STATE OF NORTH CAROLINA
DEPARTMENT OF TRANSPORTATION

August 13, 2008

SUBJECT: NCDOT Response to the § 401 Water Quality Certification Application- Request for more information. The widening of Brawley School Road and New Interchange with I-77 from SR 1109 to east of I-77 in Iredell County. TIP No. R-3833B.

REFERENCE: June 11, 2008 401 Certification Application
July 30, 2008 401 On- hold letter
Attached:
EEP Letter for Additional Mitigation Requested
Catawba Buffer Treatment Tables
Revised Permit Drawings Sheets 5 and 6 of 23
Revised Buffer Drawings Sheets 6-9 of 11
Revised Roadway Drawings Sheet 8
Revised Pre-Construction Notification

Permit Drawing
Sheet **9** of **23**

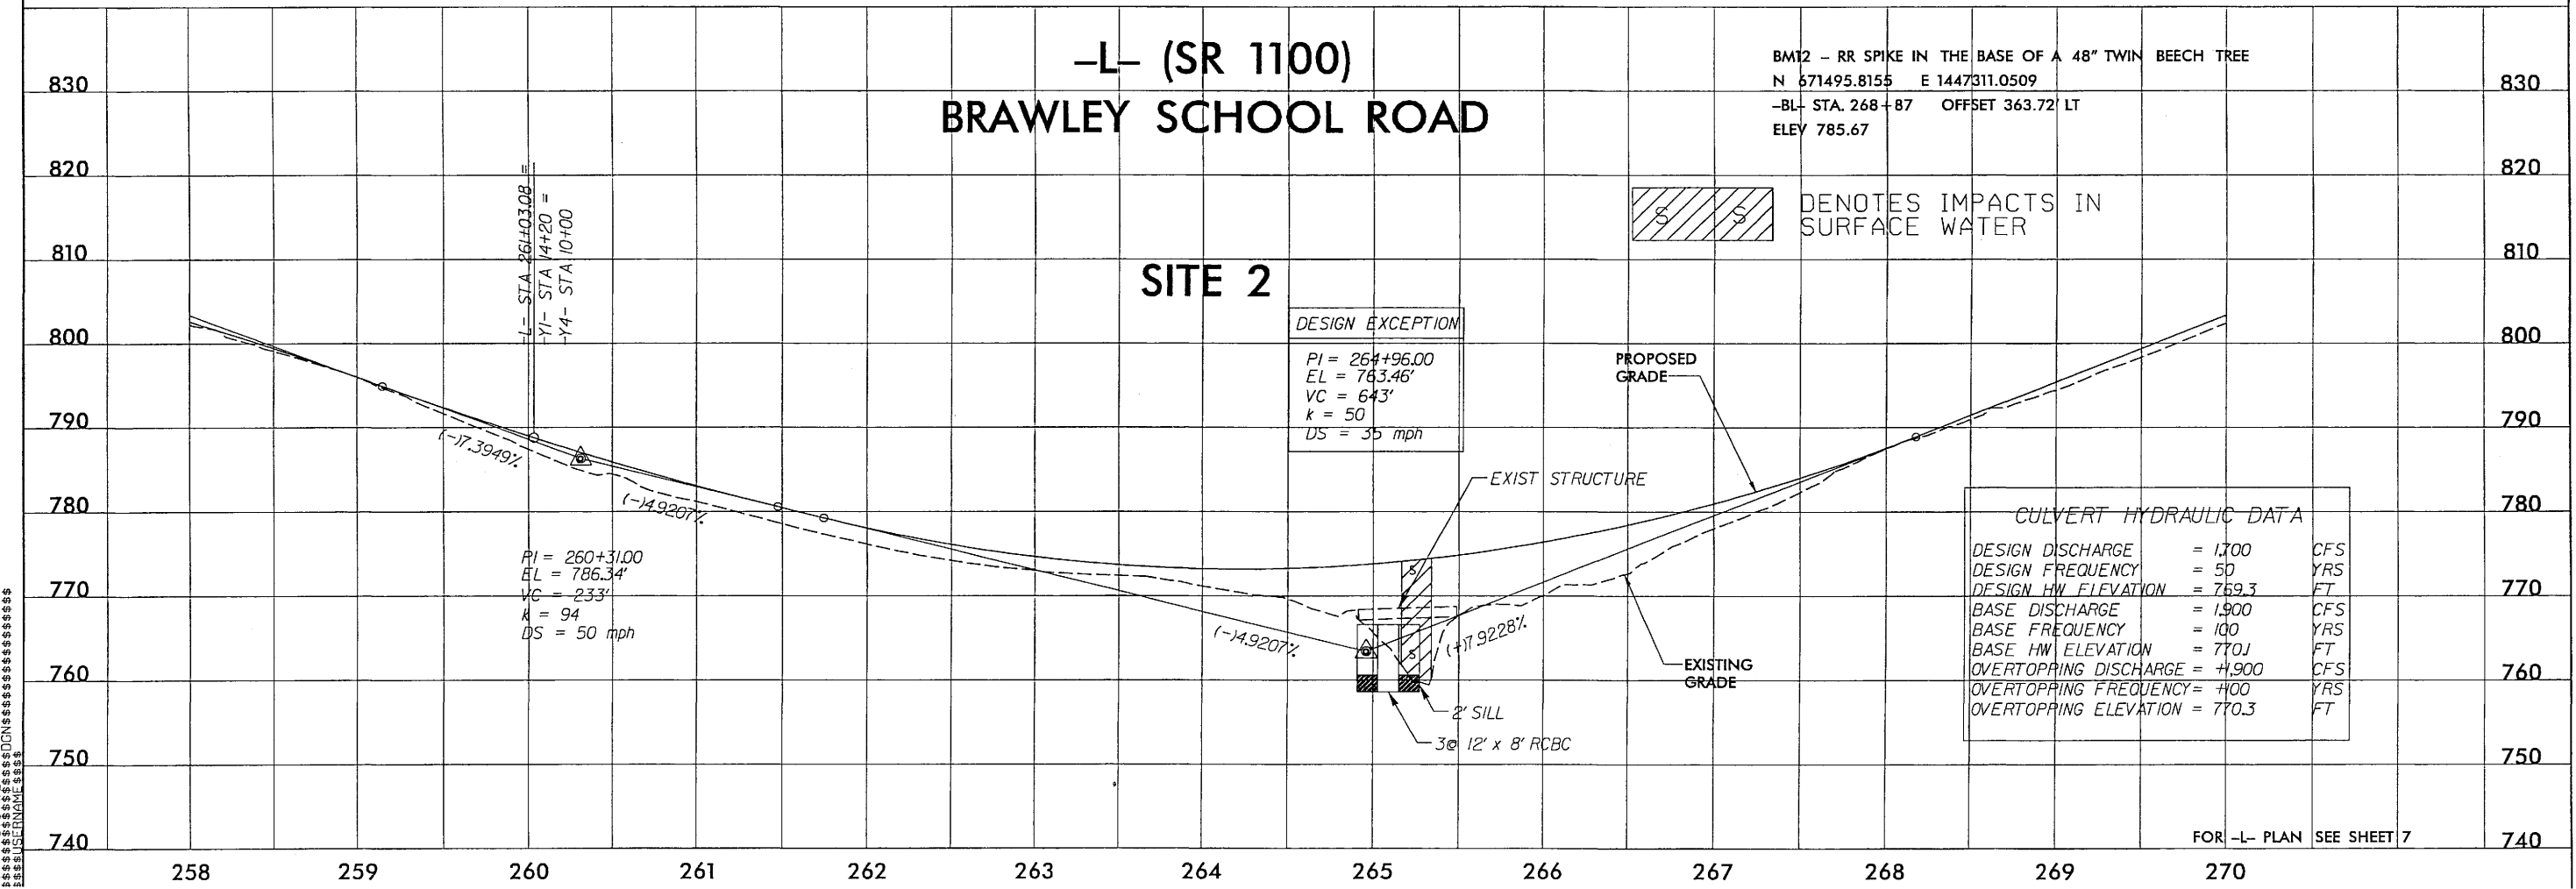
“The PCN does not propose mitigation for riprap impacts at Sites 1, 2, 3 and 4. If riprap is proposed for bank stabilization below the high water mark and is required as a result of the

installation, extension, or replacement of a culvert, riprap impacts shall be counted toward the total amount of impact which may result in stream mitigation (if the impacts exceed the 150 linear feet threshold).”

Your concern stated that “the PCN does not propose mitigation for riprap impacts at Sites 1, 2, 3, and 4.” Our original application inadvertently stated that we would not be providing mitigation at Site 3, when it should have said Site 5 (See Original Application, page 4/5, dated June 11, 2008). However NCDOT did propose mitigation for rip rap impacts for Sites 3 and 4 due to the nature of the impacts, but not at Sites 1, 2 and 5. Per NCDWQ’s request, NCDOT has obtained an additional 102 feet of stream mitigation for Sites 1, 2 and 5 with the exception of the 70 linear feet at Site 1 for the creation of a bench. This results in a total of 729 linear feet of warm water stream mitigation for this project. (This number accounts for the 90 linear feet previously acquired by EEP that will no longer be impacted due to the removal of Site 7.) See attached permit impact summary table.

Permit Drawing
Sheet 23 of 23

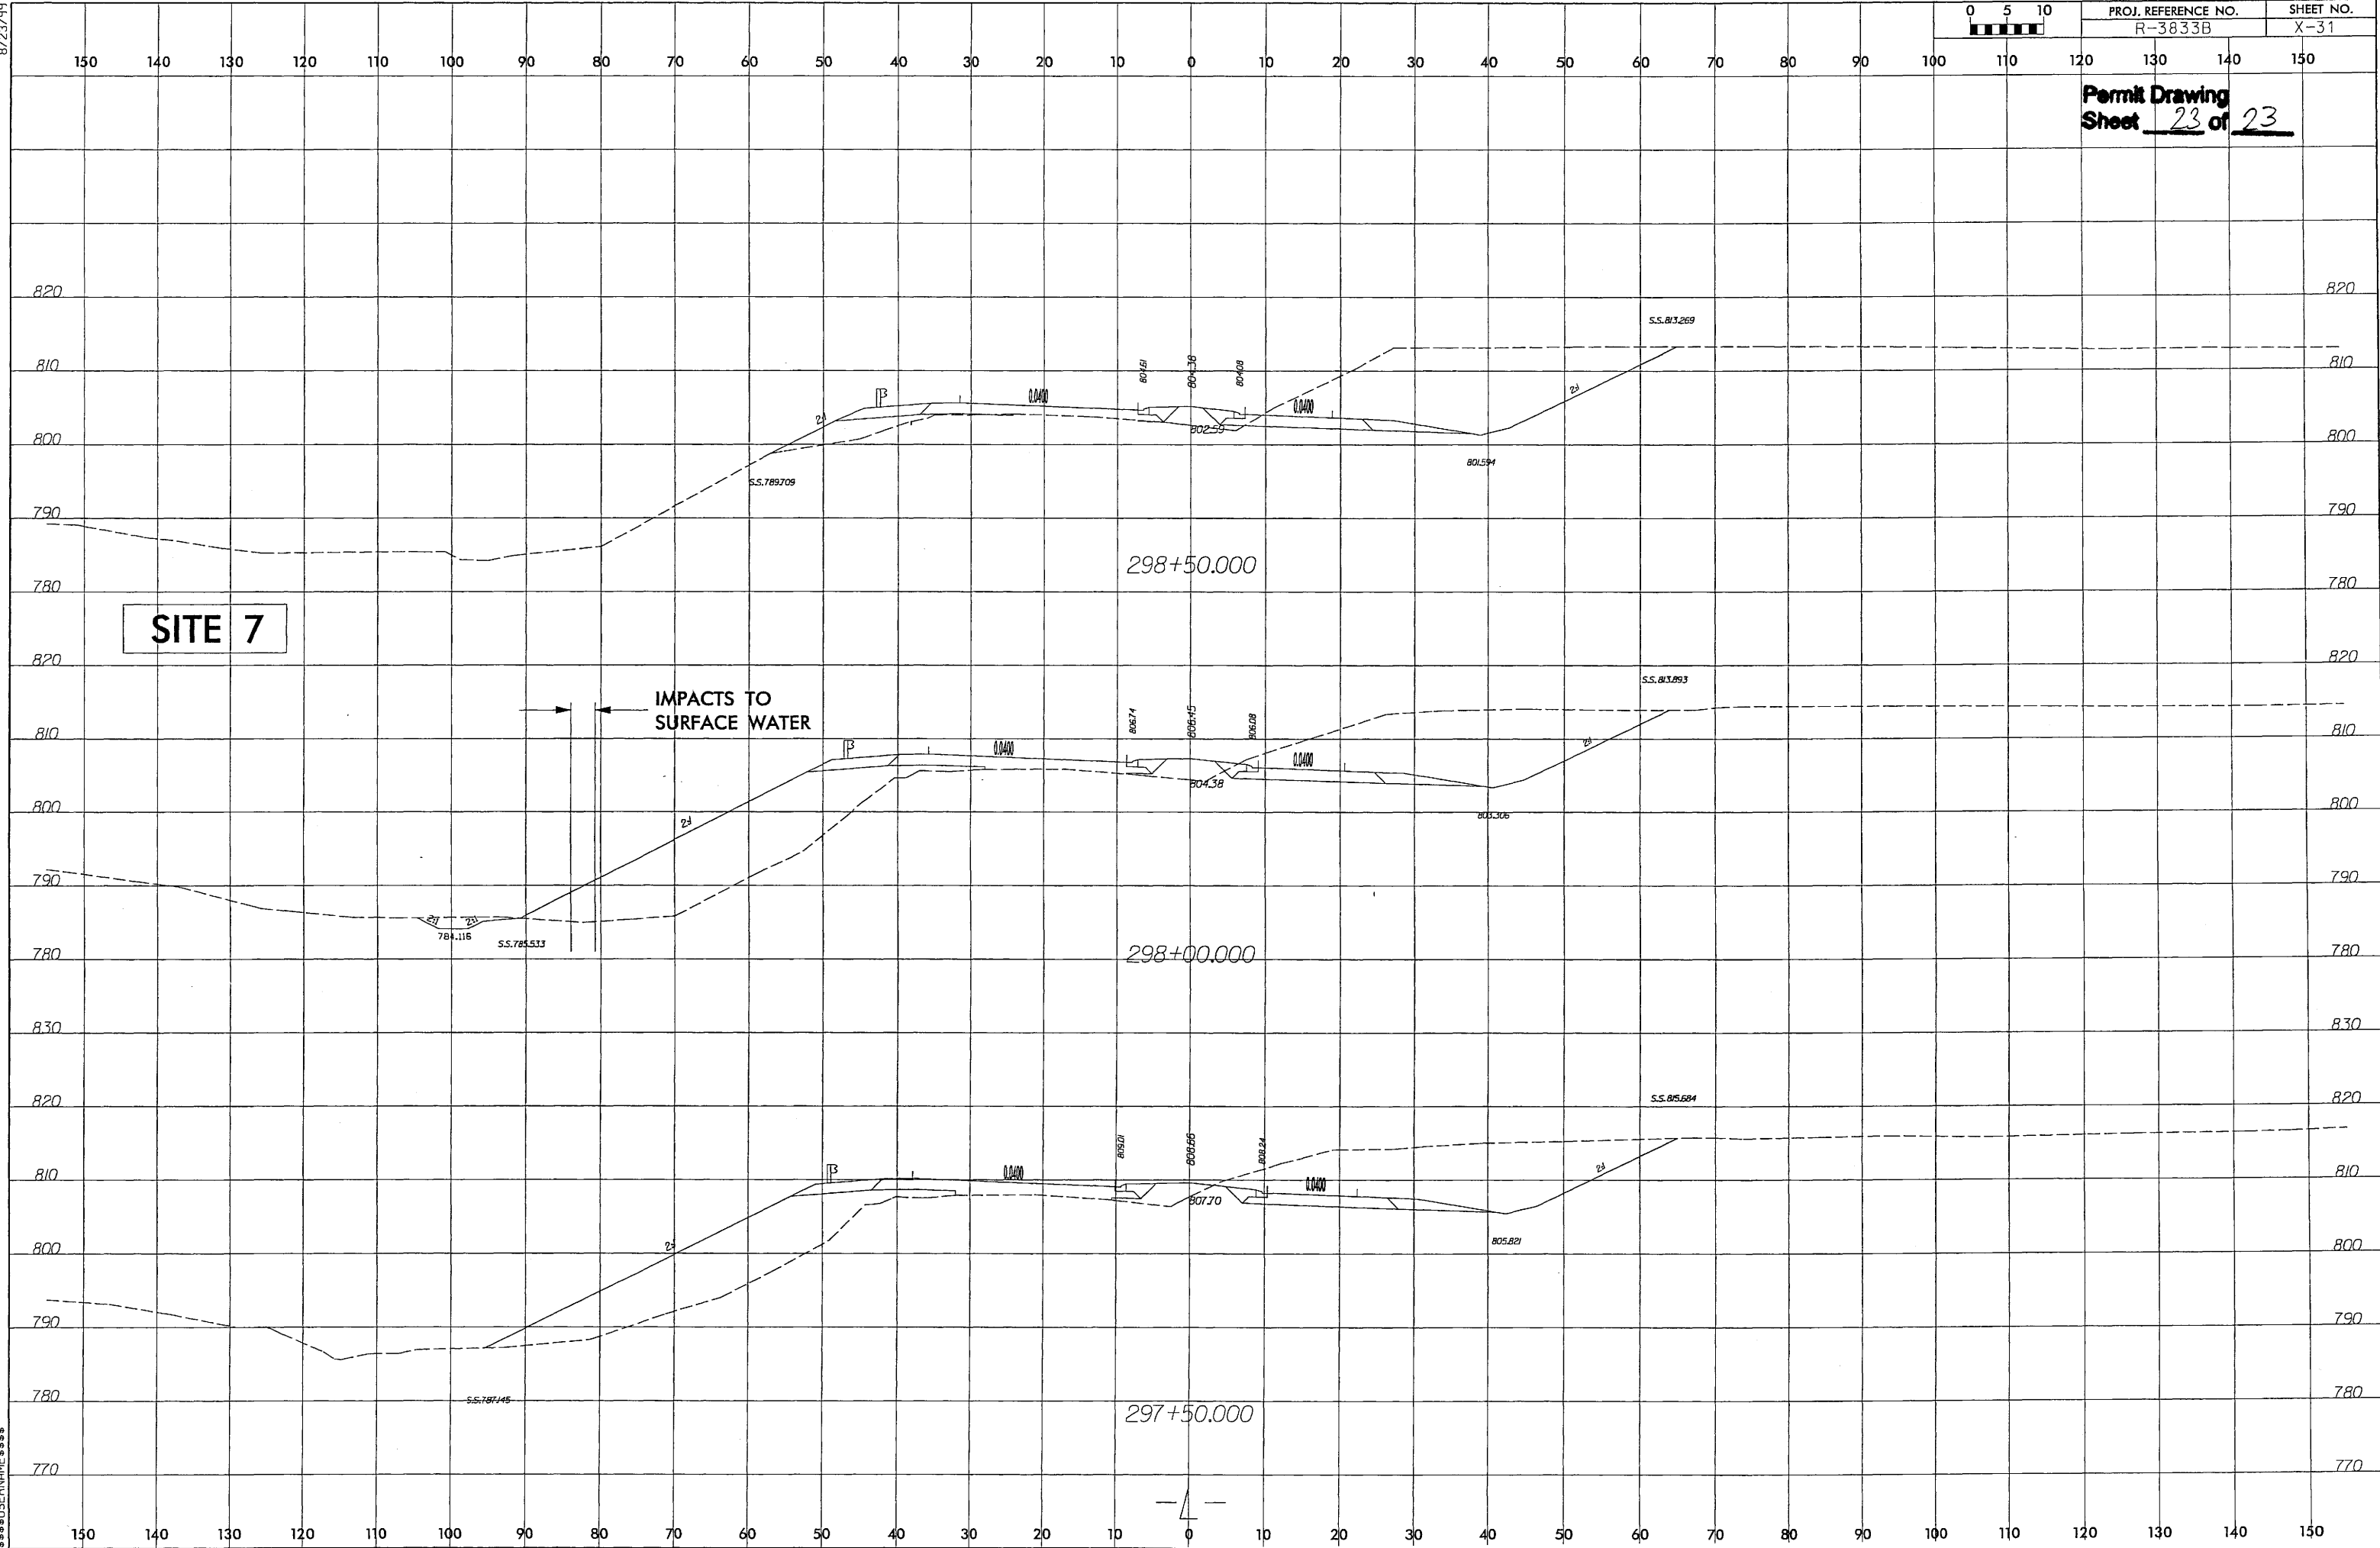
“Based on discussions, it is our understanding the impacts to Permit Site 7 will be avoided. If impacts will be avoided, please provide revised plans and the appropriate PCN sheets. If impacts cannot be avoided, please revise the impact summary table.”

Due to the shortening of the project, Permit Site 7 will no longer be impacted for this project. NCDOT has included in this response a revised PCN and plan sheets to show the project’s termination before the previous “Site 7”. This reduction will reduce project impacts by 90 linear feet.
